Harnett County

Permit Number: **SIGN2506-0007**

Description: **Scooters Coffee Monument Sign**

Site Address: **130 BRANDYWOOD CT**

2 of 3

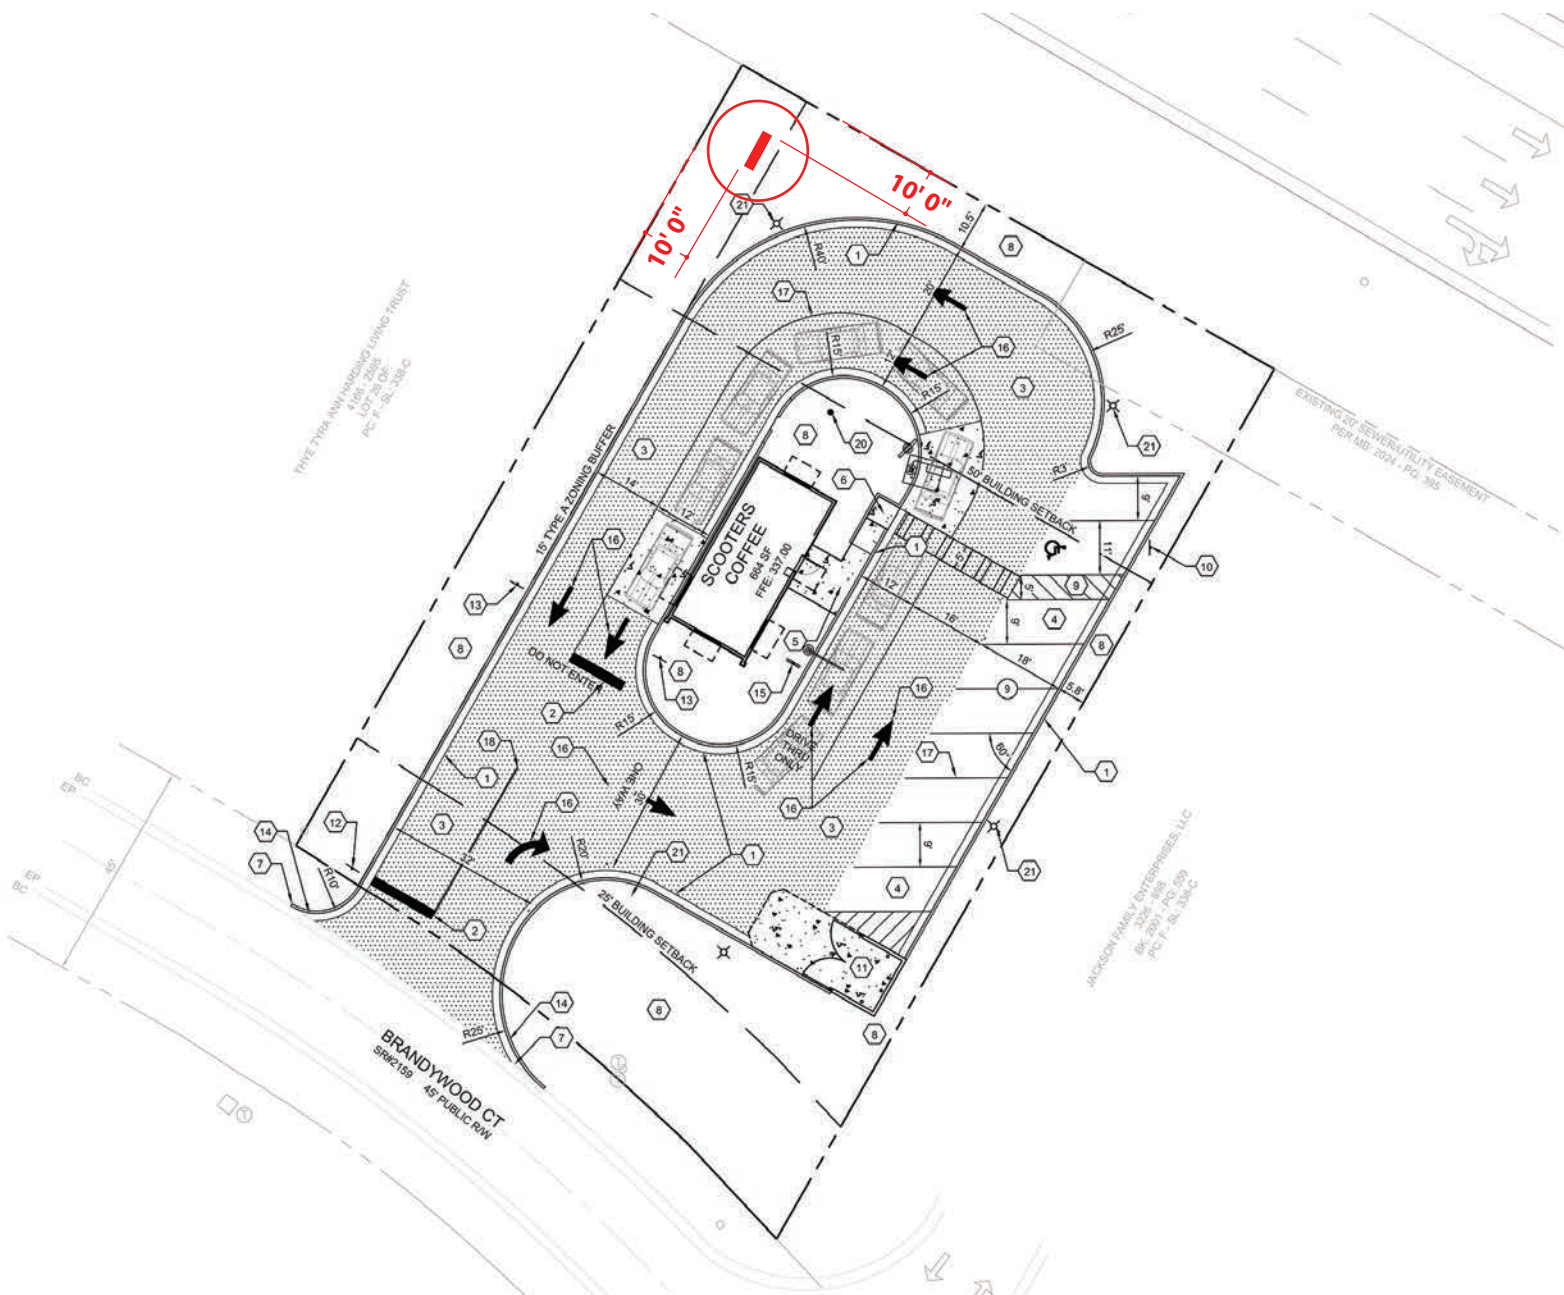
SENT DATE	RETURNED DATE	DUE DATE	TYPE	CONTACT	STATUS	REMARKS
Review Group: ALL						
6/11/2025	6/17/2025	6/25/2025	COMMERCIAL BUILDING REVIEW	Brad Sutton	DISAPPROVED	
Notes: Need sealed structural drawing for sign review						
Review Group: AUTO						
6/11/2025	6/16/2025		COMMERCIAL INTAKE	CP Bucket	DISAPPROVED	
Notes:						
6/11/2025	6/16/2025	6/16/2025	PLANNING	Randy Baker	APPROVED	
Notes:						
6/18/2025	6/18/2025	7/2/2025	COMMERCIAL BUILDING REVIEW	Brad Sutton	DISAPPROVED	
Notes: Still do not have sealed drawings for structural with code compliant design information						
6/18/2025			COMMERCIAL BUILDING REVIEW	Building Bucket		
Notes:
